FIGURE 6 Bicycle Network Surrounding MMC

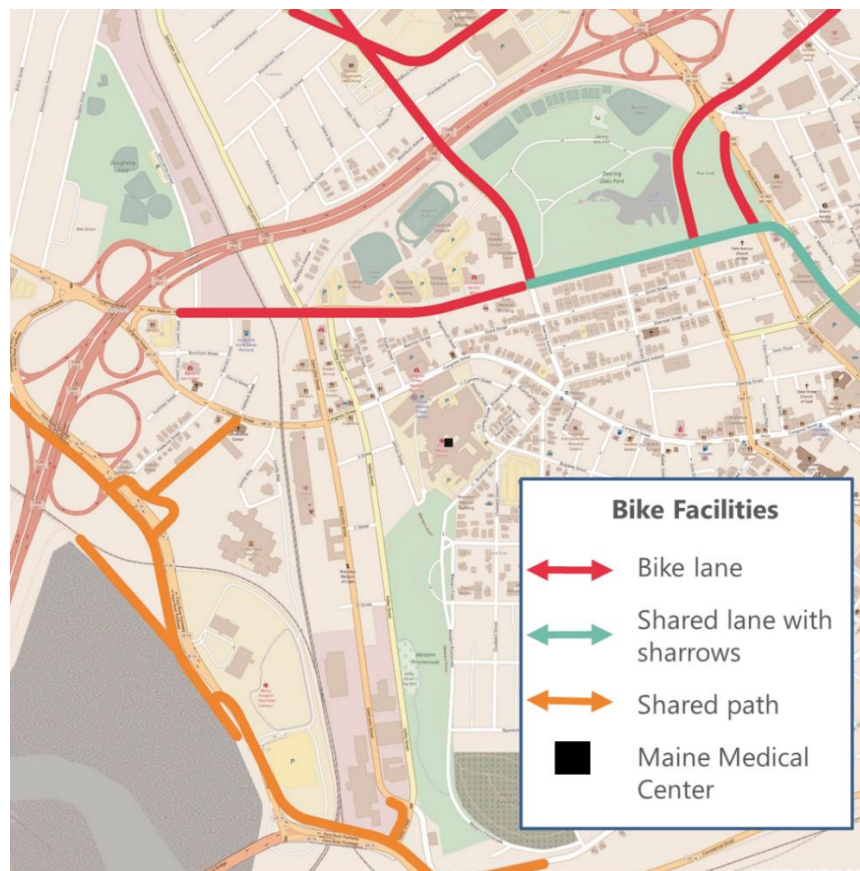
- Figure 6 should include both the existing and proposed bike network (see attached markup).
- The TDM plan notes that vanpool and carpool vehicles will get preferential parking spaces in the new employee garage. The location of the new garage may actually be a barrier for increased carpooling. We would suggest identifying spaces on-campus.
- The 'pay for parking' section is in the future tense. This should be in the future strategies section.
- The plan should also clarify the cost for parking – is it \$3 per week or bi-weekly? Paying for parking (and allowing cash out) is potentially one of the most significant things the hospital could do to shift mode share. Fees could/should be increased significantly.
